From: Planning
Subject: FW: 3/2025/0639 - Springwood, Hurst Green

From: McCrone, Peter <
Sent: 01 October 2025 13:44
To: Maya Cullen <
Subject: RE: 3/2025/0639 - Springwood, Hurst Green

Thank you for your e-mail. I have looked at the report submitted, and Doug Moir's comments on an earlier version.

Figure 5: Cruck 1

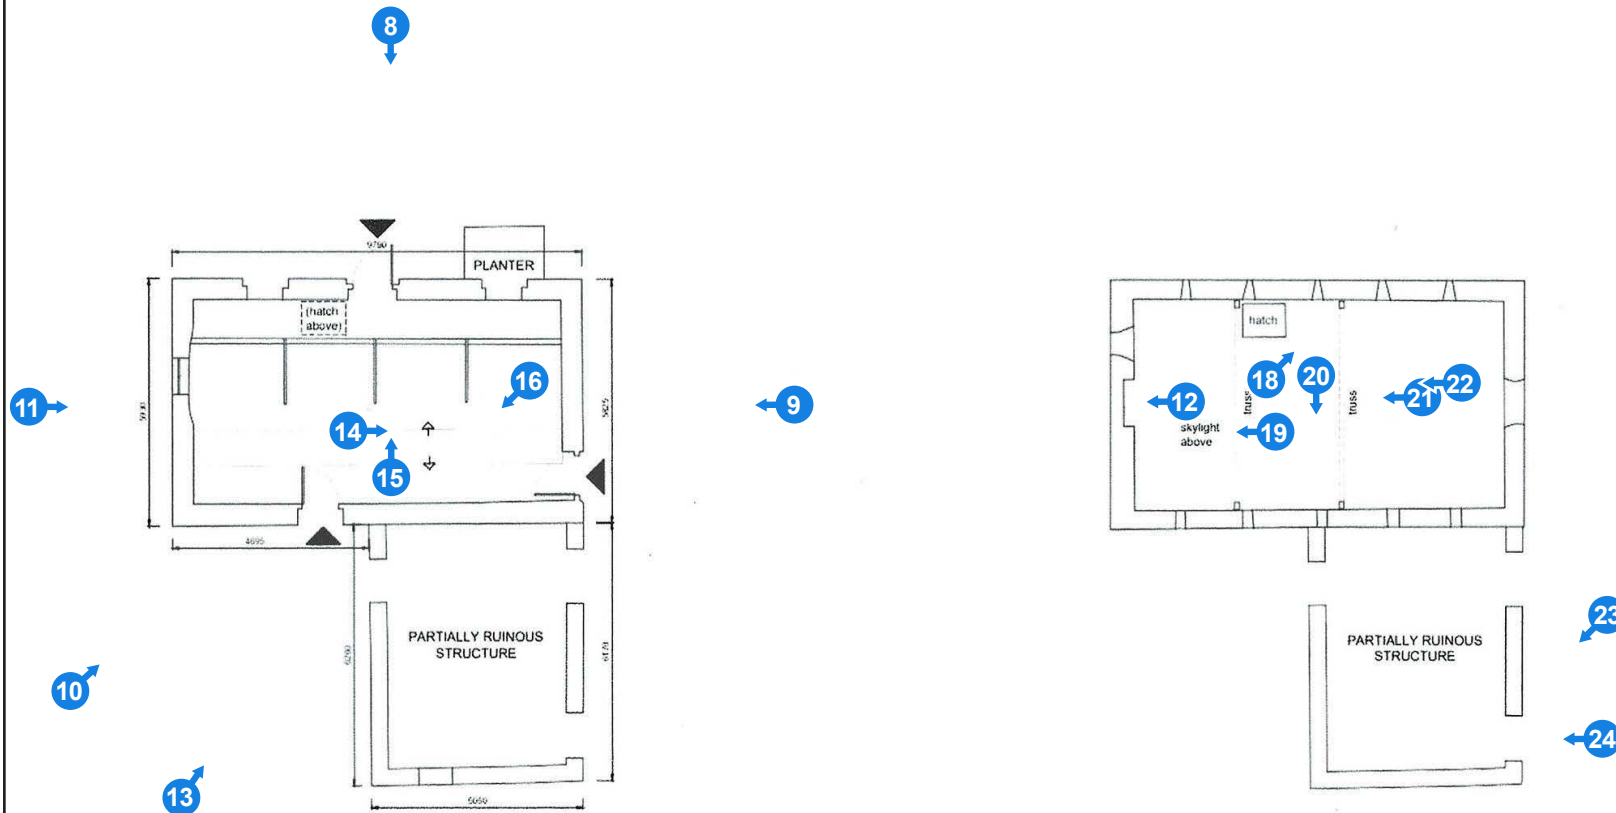
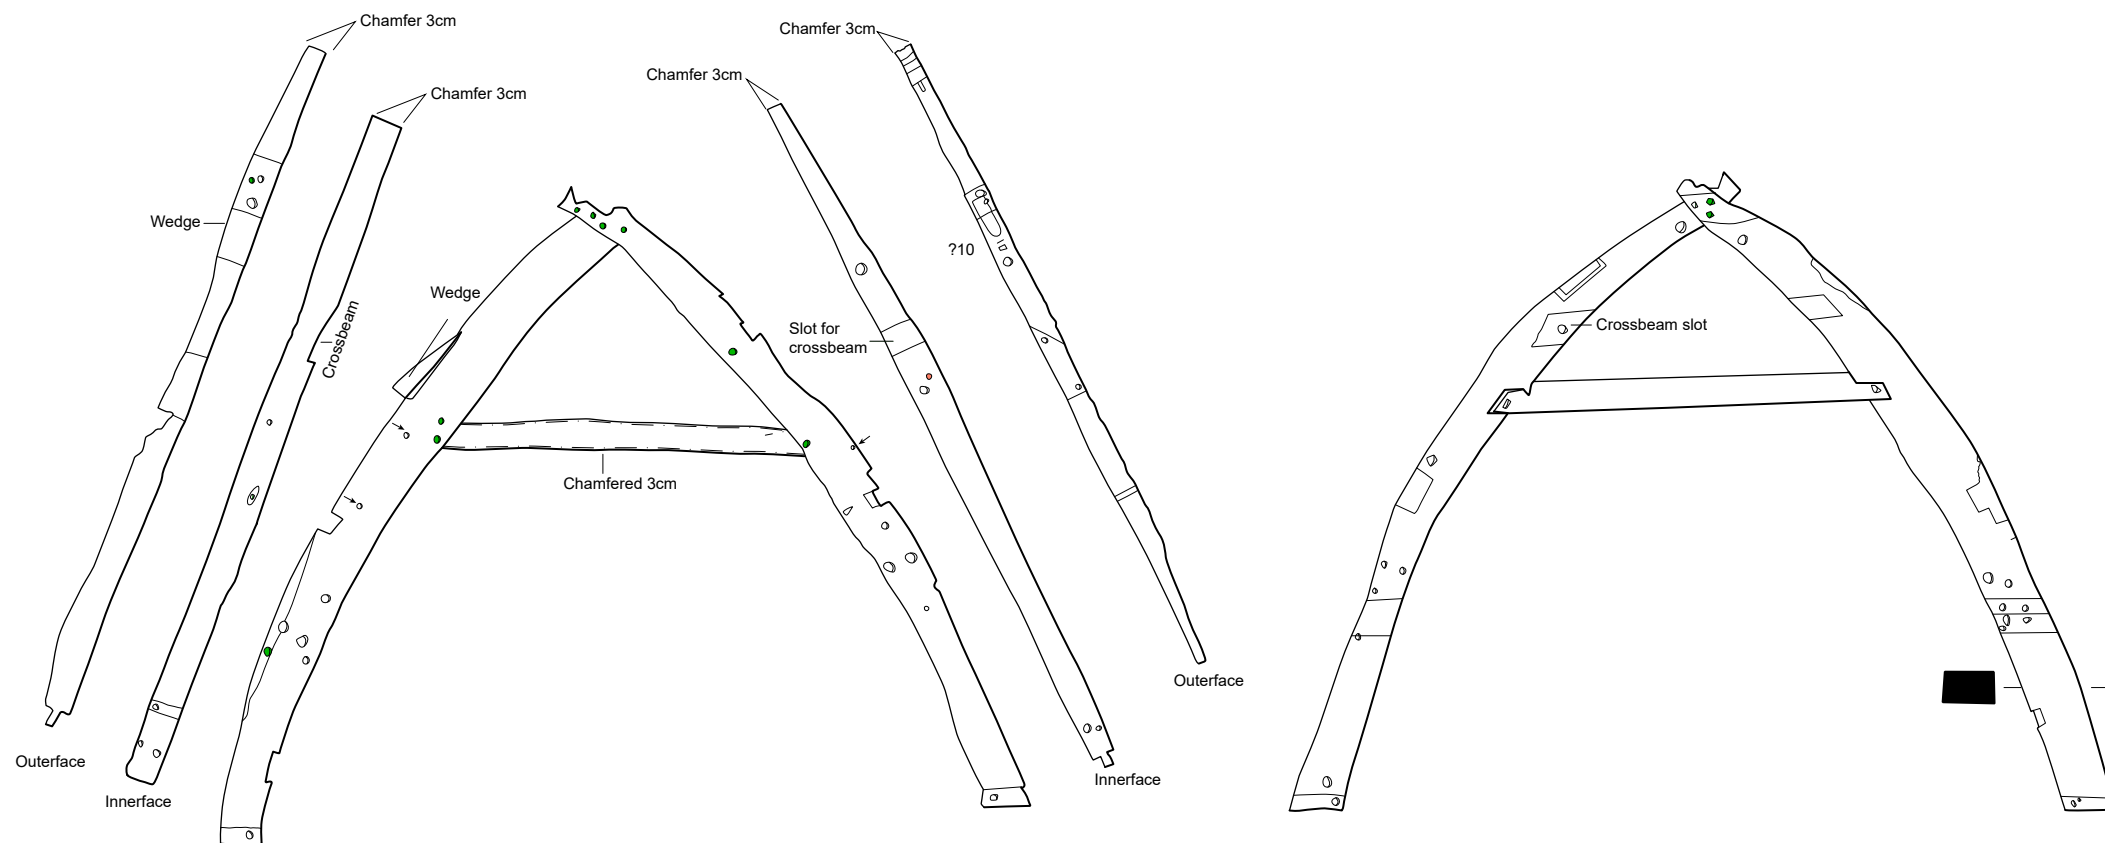
The matter of dendrochronological dating of the timbers of the cruck truss timbers has not been addressed. Dendrochronology (using the variations in the width of growth rings in timbers and comparing sequences of these compared to a "master chronology" nationally, regionally or locally to obtain either the felling date of the timbers, or a near approximation usually to within about twenty years) where the timbers are suitable is fairly essential in understanding the building's history and construction. Cruck construction was used over a long period (at least several hundred years) and upper crucks (where the cruck feet rest on a ceiling beam of the ground floor) are thought to be later (perhaps from the late 16th through to the 18th century, than the full height crucks (also found in Lancashire). Information that can be obtained from dendrochronology include determining if the cruck blades were formed by halving a single tree to get a matching pair, if the blades are from different trees, and if the trusses have different felling dates which would suggest they were salvaged and reused from earlier buildings (as do, in this case, the presence of empty joints and peg holes).

It is, unfortunately, the case that we cannot advise the condition be discharged until there are appropriate amendments, and in the case of the missing dendrochronology study, a reasonable justification for omitting this.
